SPR EA1N and EA2 PROJECTS

DEADLINE 13 – COMMENTS ON DEADLINE 12 FLOOD RISK RELATED SUBMISSIONS

Interested Party: SASES PINS Refs: 20024106 & 20024110

Date: 5 July 2021

Appendix 3: Infiltration Basin Figures

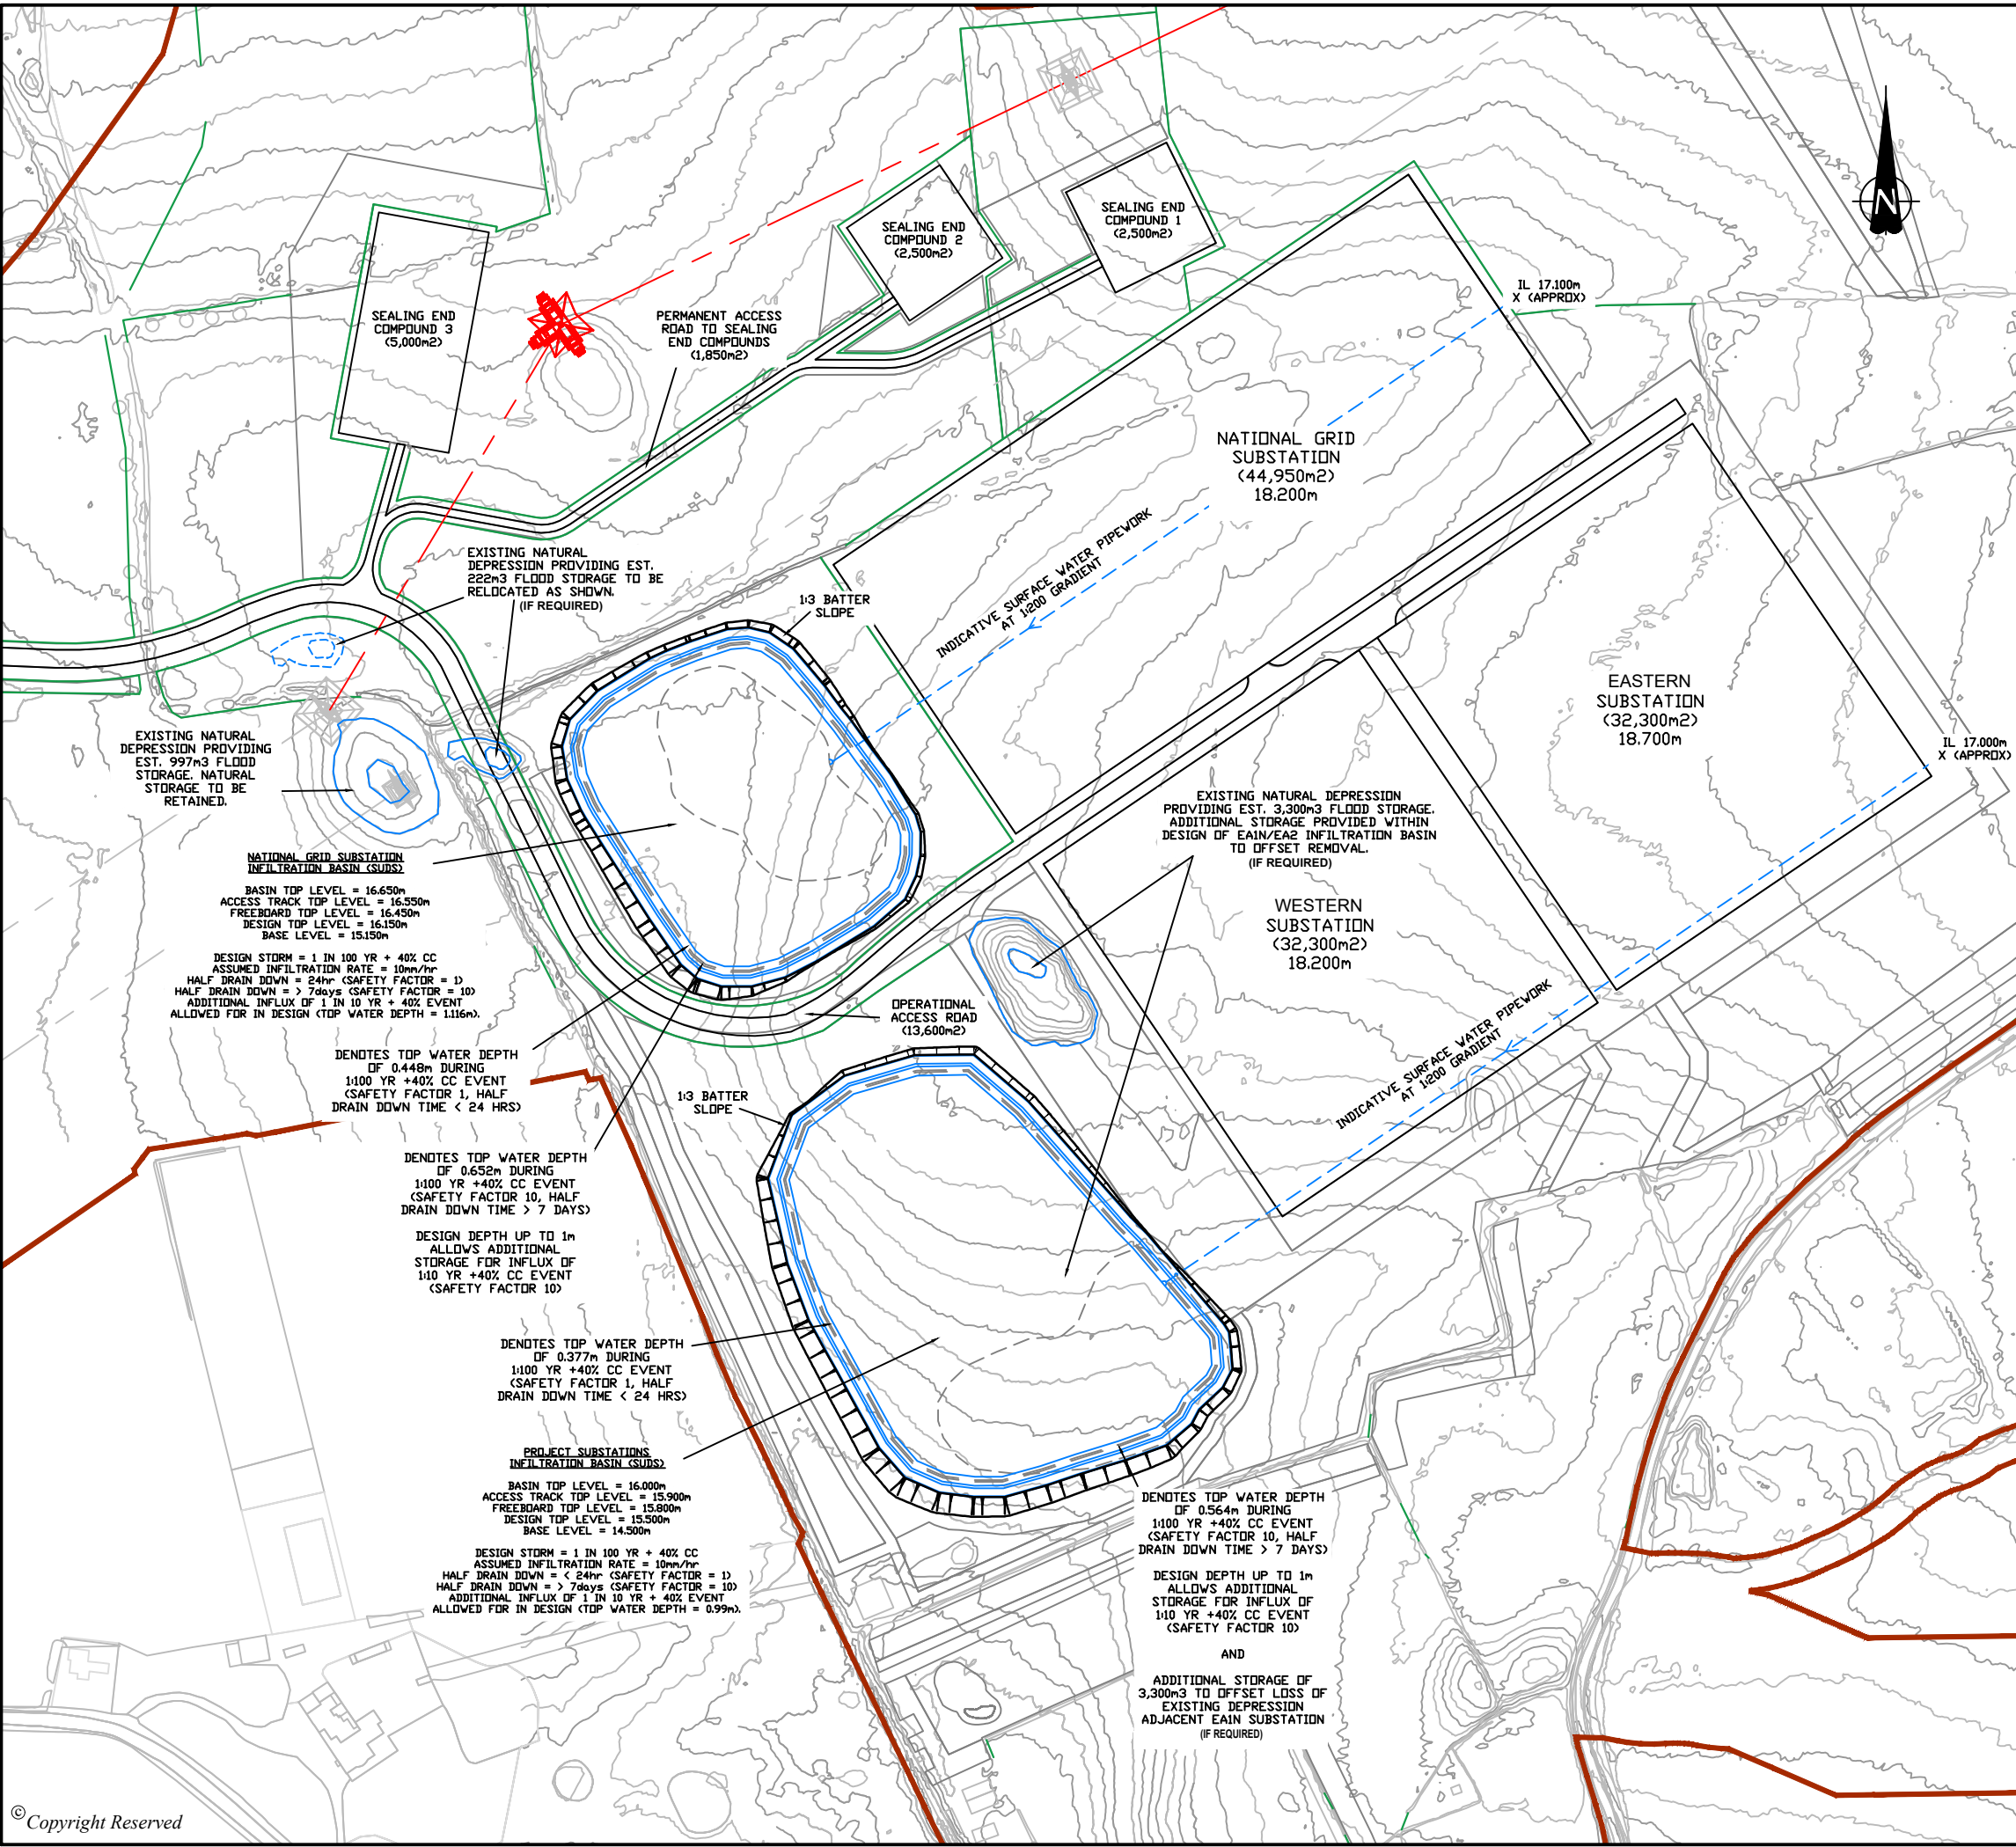
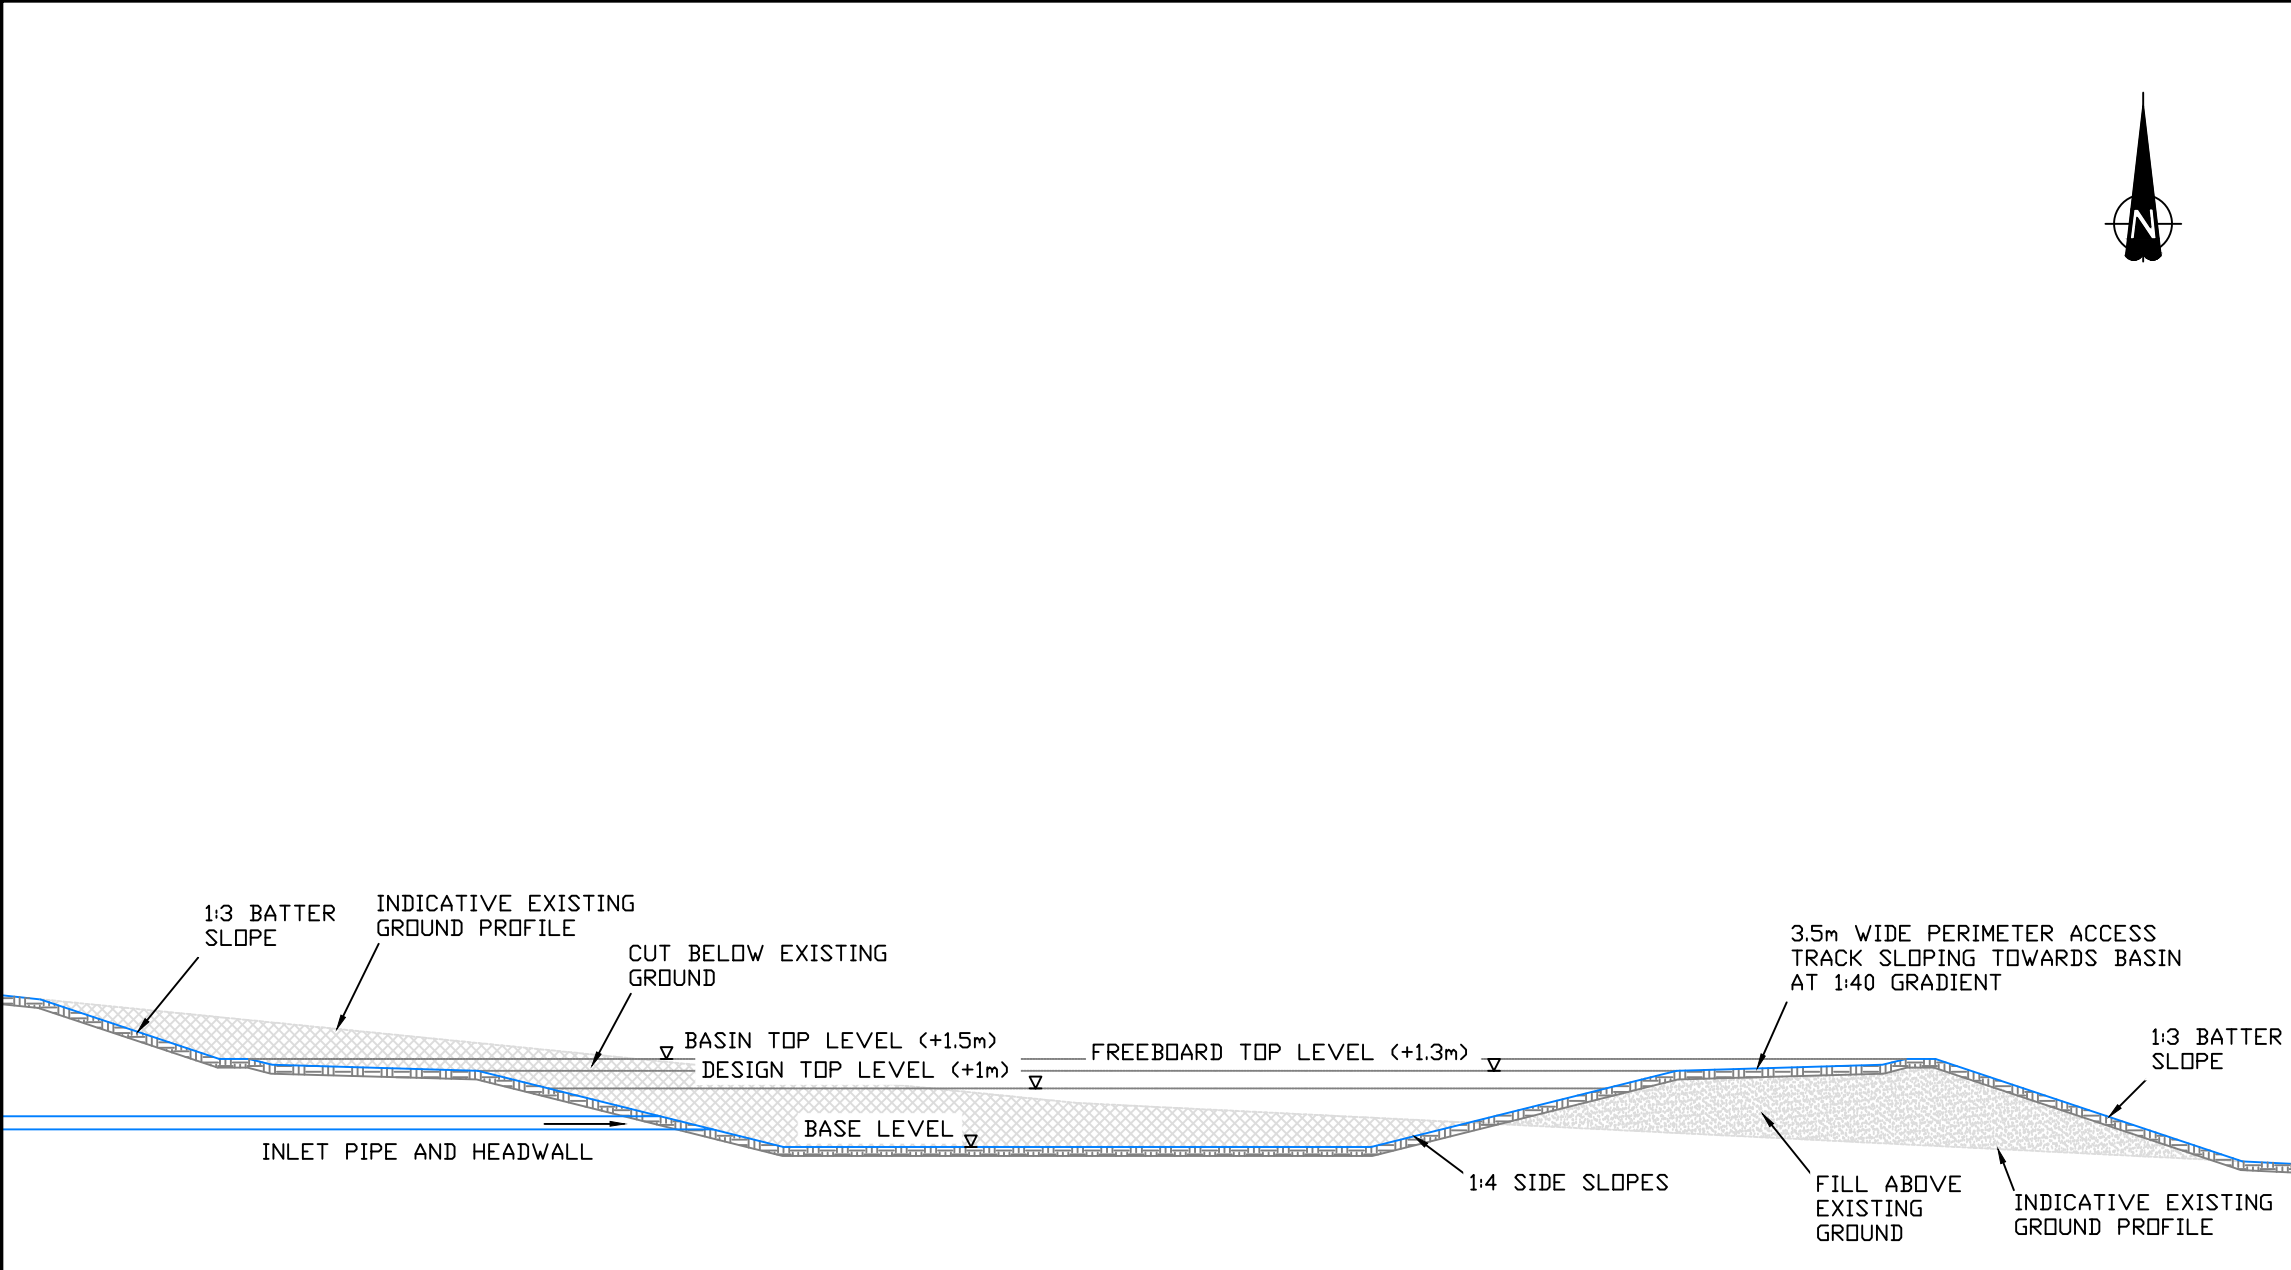
GWP agree the tests are not in accordance and consequently over-estimate the infiltration rates. However the tests were also not excavated to the same depths as the proposed infiltration basins and due to their geometry measure horizontal permeability whereas basins will be dominated by vertical permeability – which can be an order of magnitude lower.

GWP notes the infiltration values considered inadequate are greater than those stated as the acceptable minimum in previous SCC submissions of 10mm/hr. We contend the SUDS hierarchy response should be to increase the size of the basin to ensure sufficient infiltration can occur, not to abandon infiltration. In not following the SUDS hierarchy the SCC is in breach of its own policy.

GWP note groundwater flood risk to Friston village resulting from the infiltration basins, as well as rising groundwater levels (due to the basins) reducing the infiltration basin performance have not been mentioned by SCC – yet both issues challenge the viability and acceptability of the infiltration options – see further paragraph 16 below.

GWP disagree with this conclusion. Both basins meet the minimum infiltration rate previously requested by SCC of 10mm/hr. The reason the Applicant does not pursue infiltration only is because of the limited area available for infiltration due to lack of land availability and other landscaping and biodiversity constraints and requirements. The SCC decision to move away from infiltration only is not therefore based on flood risk alone, but on the viability of infiltration constrained to the areas defined in the Applicants' DCO applications.
